CITY OF ALBUQUERQUE

**RE: MDS - Montage Subdivision Unit 7 on Bobby Foster
Grading and Drainage Submittal for Preliminary Plat and Grading Permit
Engineer's Stamp Date: 6/30/22
Hydrology File: R16D100A**

Grading Plan Submittal

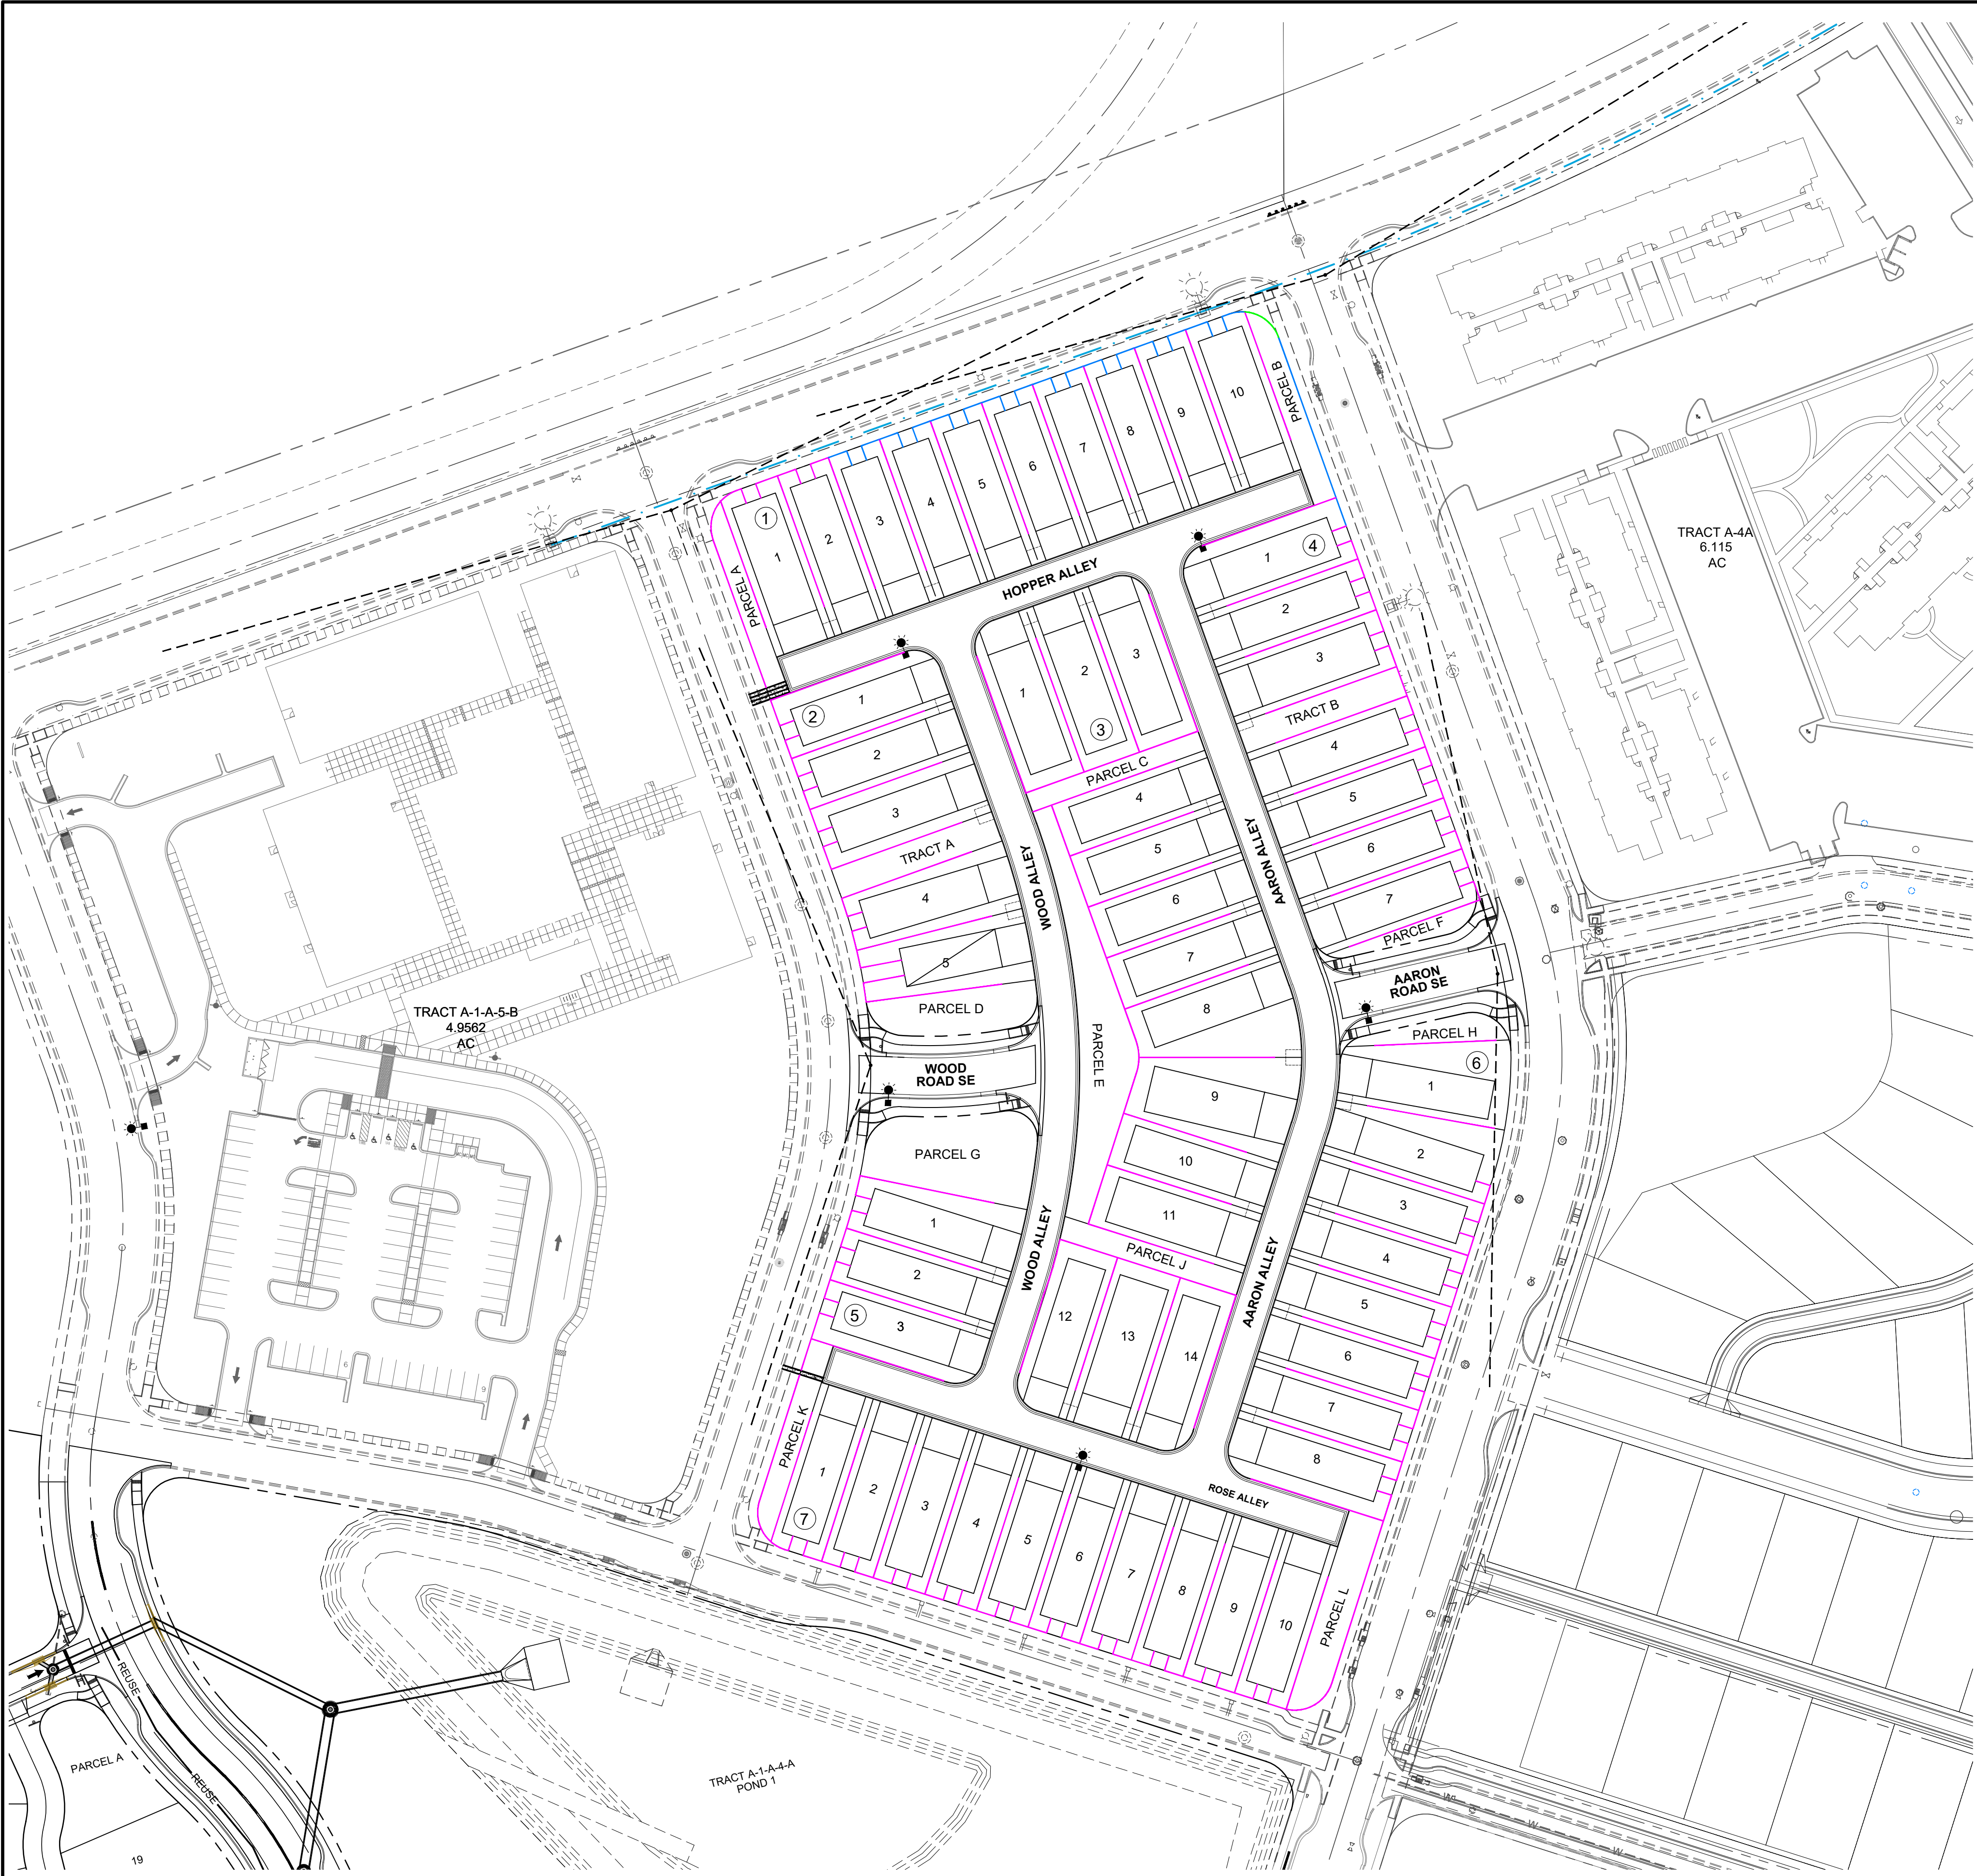
1. The Grading Plan was missing and is required. Include typical section of streets, alleys, retaining walls, etc. Show both existing and proposed storm pipes and inlets with sizes.
